Planning - Case Comments

Project Number: PR-2022-007805

Application Numbers: SI-2024-00849

Project Name: *Roses Southwest Papers – Crick Crossing between Watson SE and Hawking SE*

A1 SITE PLAN - DFT
SCALE: 1" = 80'-0"

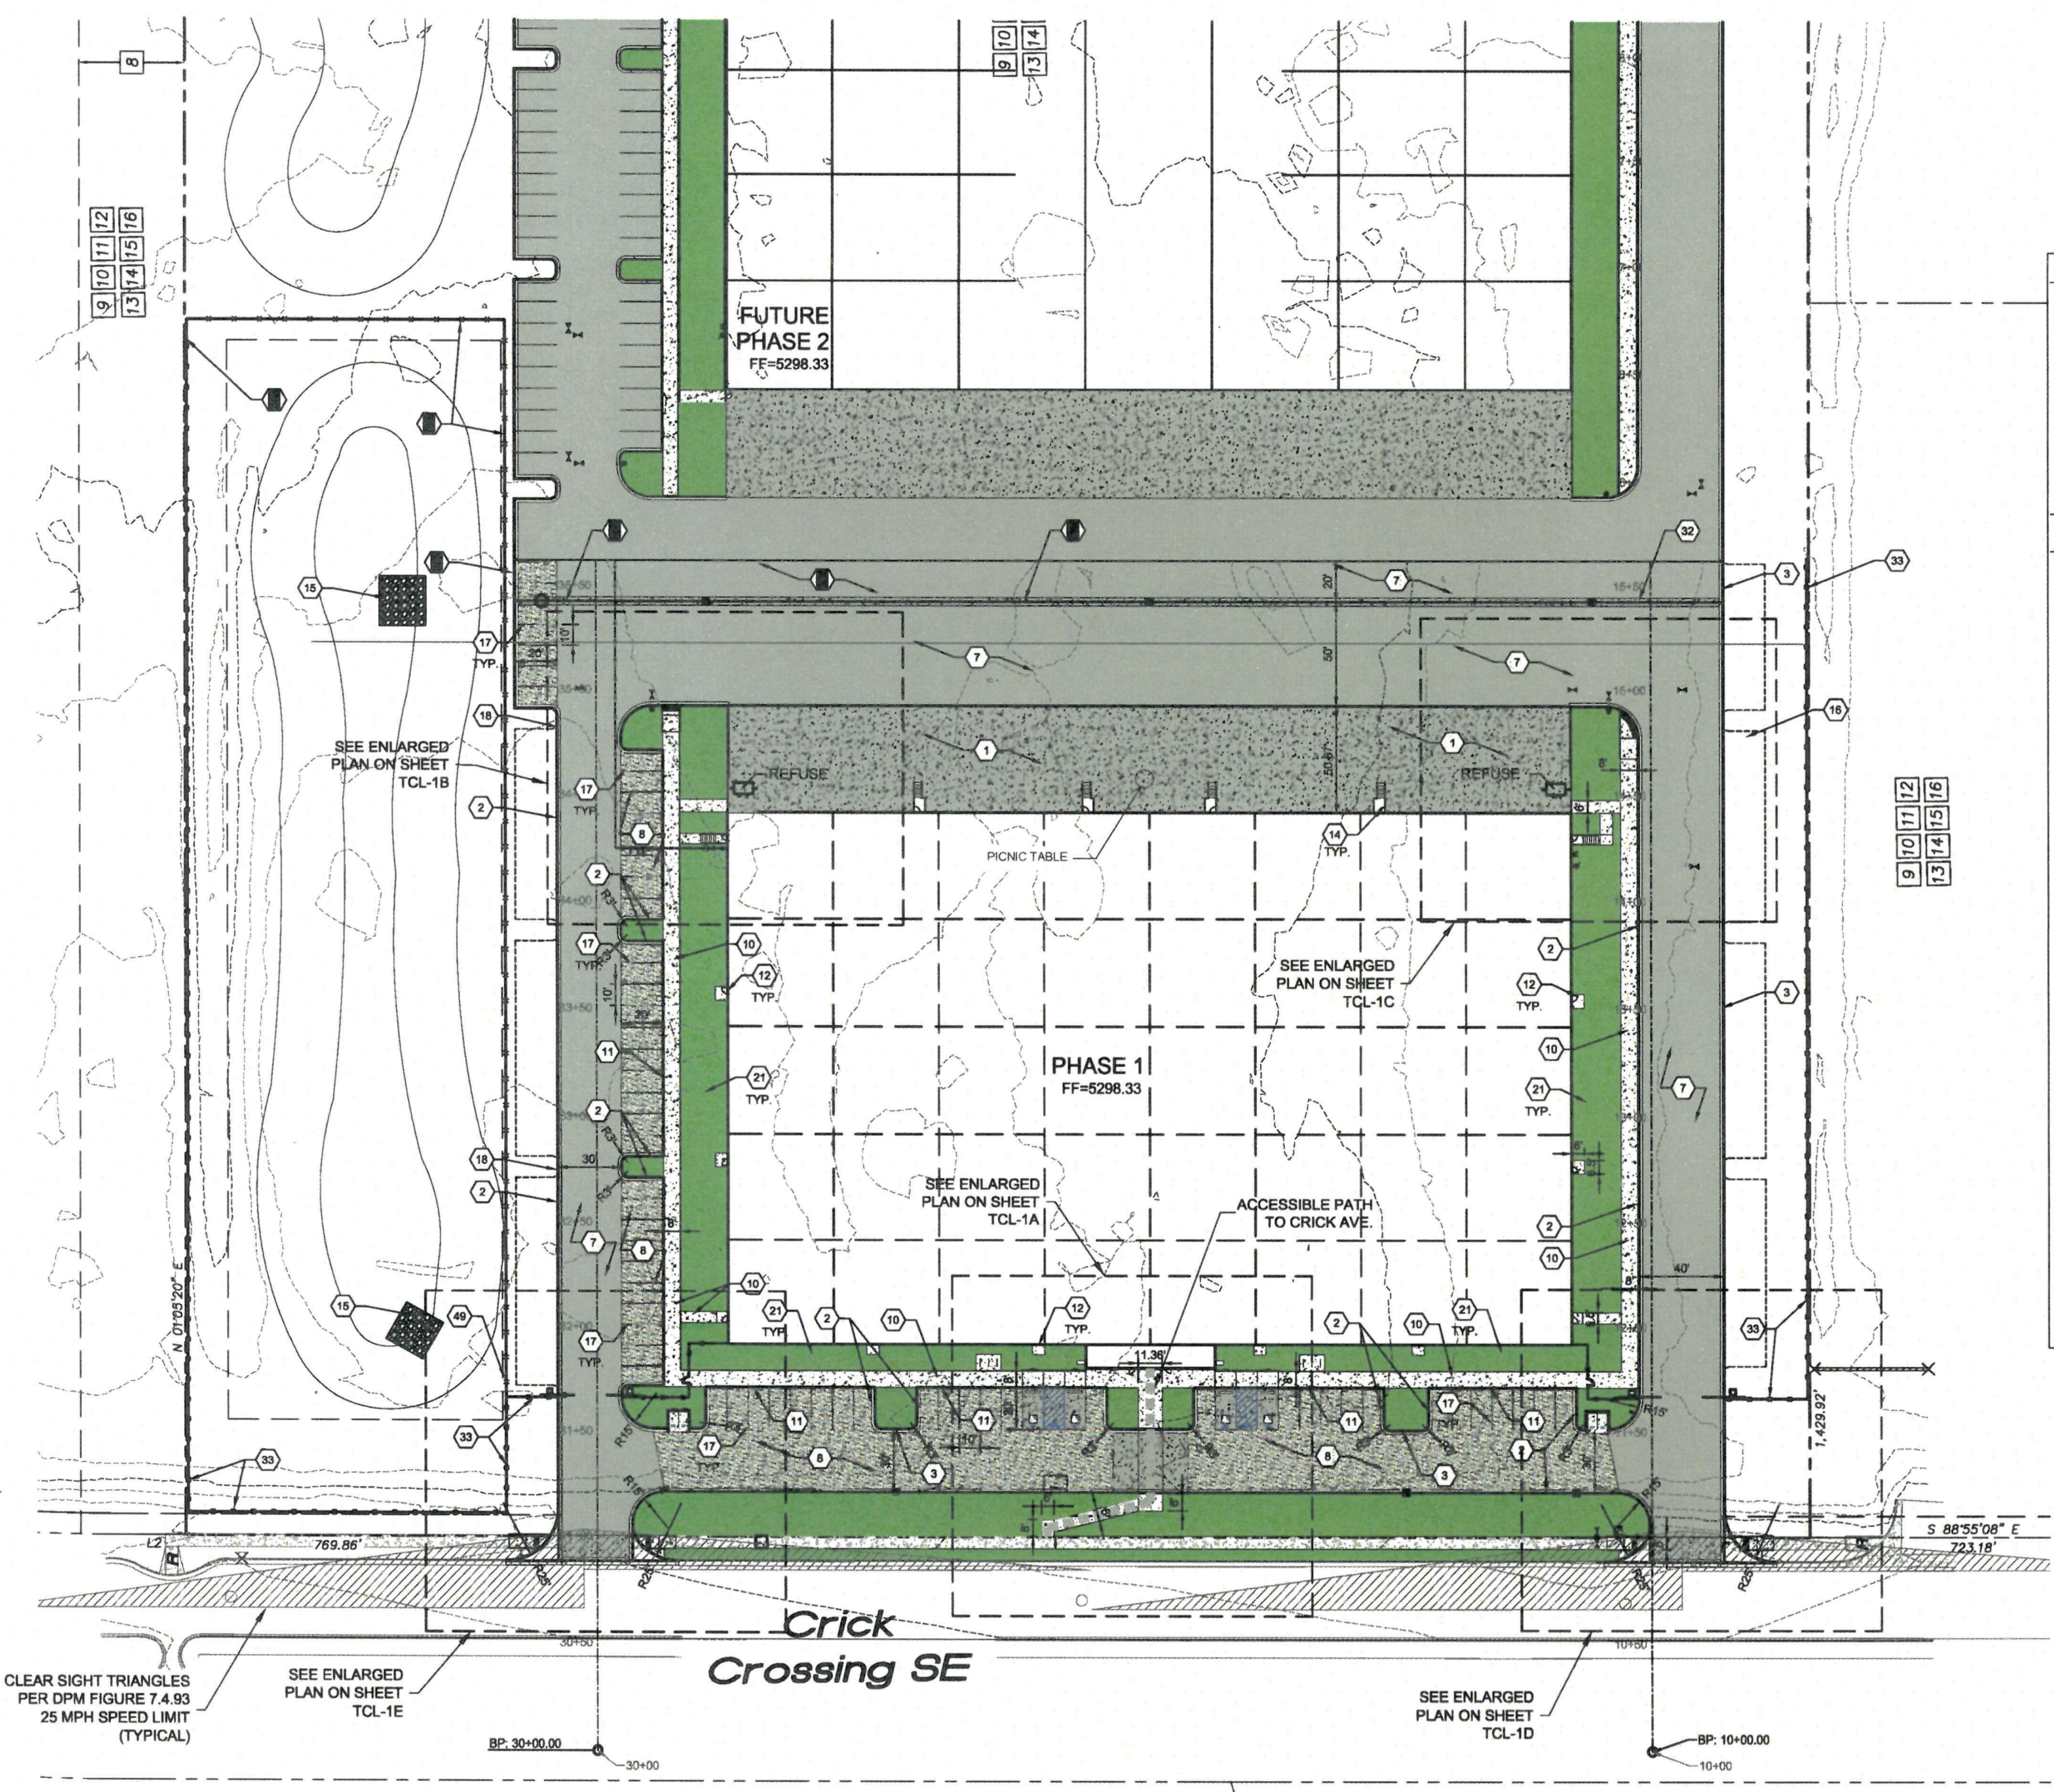
- The applicant proposed three project phases on the one lot, but is only detailing phase one in this site plan submittal. Therefore, future phases must have site plan approval processed as a Major Amendment to this site plan. Place the following note next to each future phase:

'Future Phases III: Must be approved as a Major Site Plan Amendment' Note added.
 - Site Plan sheet seems to be missing from the set. Provide a Site Plan including the project data and calculations, and with a DFT signature block. **Sheet added.**

- All plan sheets must be signed and sealed by a professional licensed in the state of New Mexico. **Stamp added.**
 - Project and application numbers must be added to the site plan sheet. **Numbers added.**

'Future Phases II: Must be approved as a Major Site Plan Amendment' Note added.

SHEET TITLE
Landscape Plan

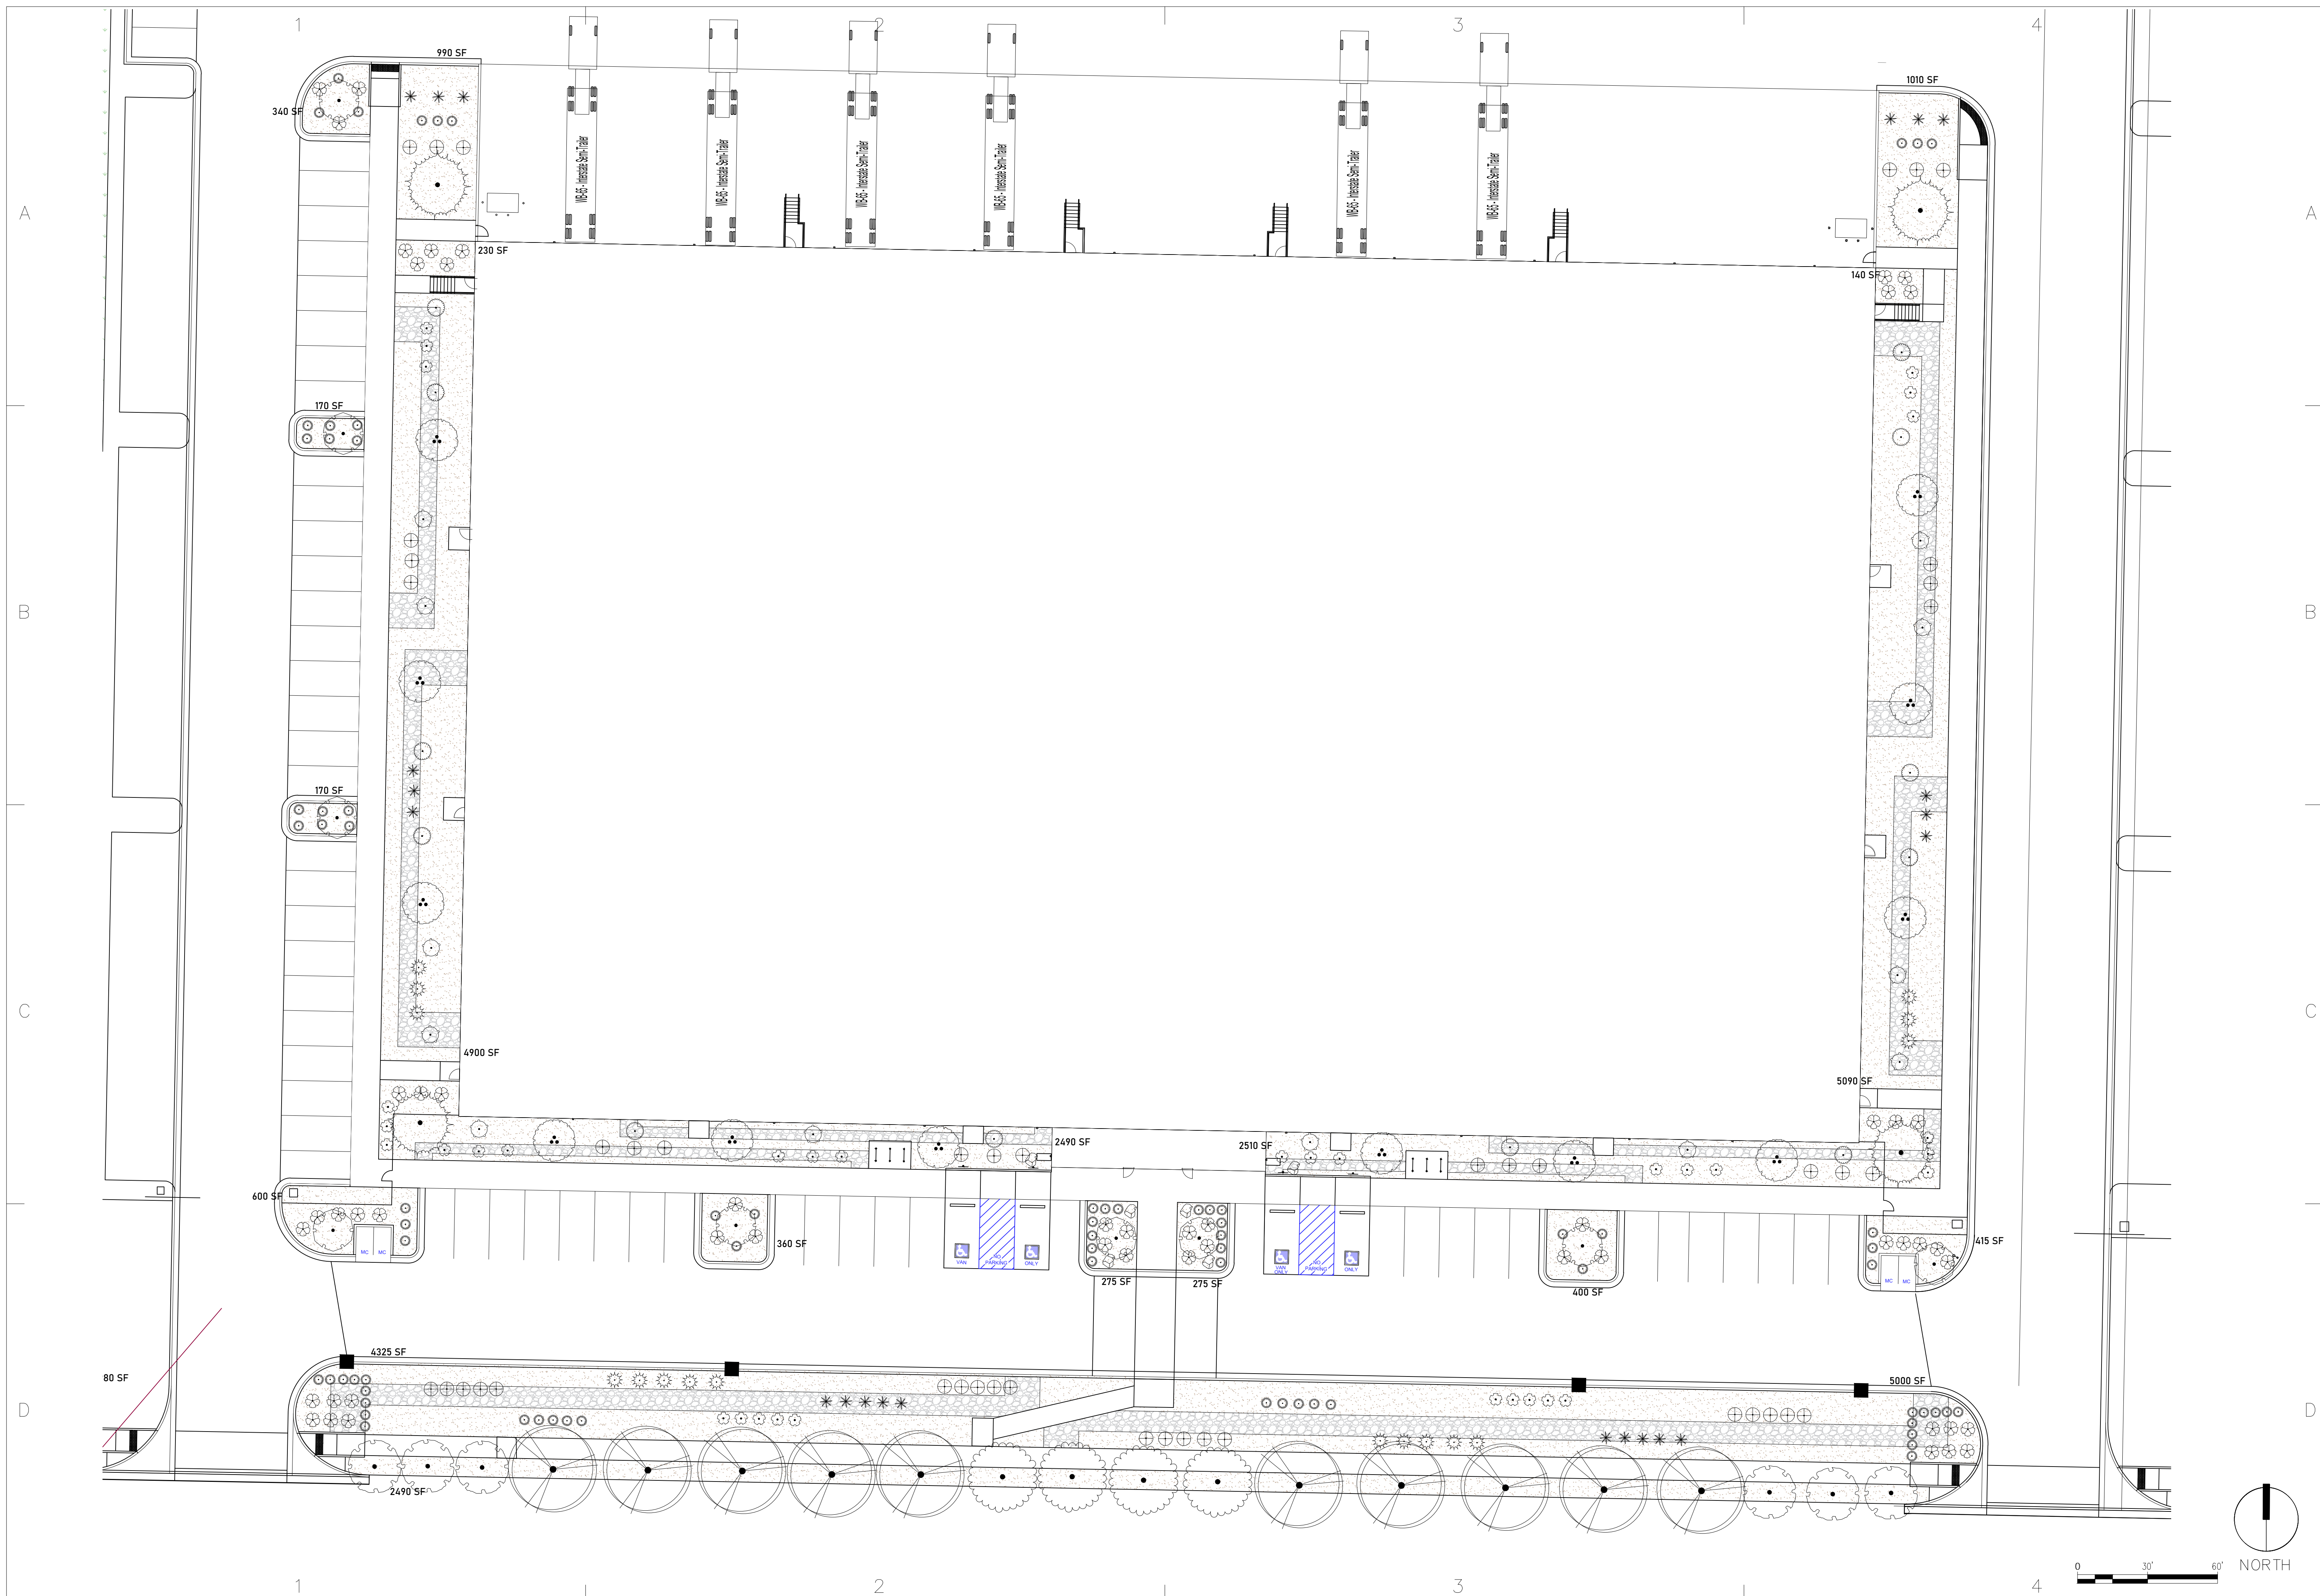
1. Landscape requirements apply to surface parking only.
2. Required parking area trees may be of a deciduous or evergreen species.
3. Landscape coverage: 50% of all tree canopies shall count towards the requirement that 60% of landscape areas be covered with living, vegetative materials. **Landscape coverage must be provided on the plant legend and relevant calculations must be added to the landscape data.**
4. Water harvesting areas for surface runoff shall be provided in parking lots. Permeable paving can be counted toward this requirement. **Confirm compliance**
-Landscape calculations seem to be inconsistent. Provide accurate landscape calculations.

- Per **5-6(C)(2)(c)** The mature realistic spread of trees and shrubs will be used to calculate required vegetative coverage as follows.
 1. Tree canopies and ground-level plants shall cover a minimum of 75 percent of the total landscape area as measured by canopy width or the area beneath the dripline of the mature size of the actual vegetation.

The tree planting detail must reflect this requirement.

Please refer to updated Landscaping Sheet.
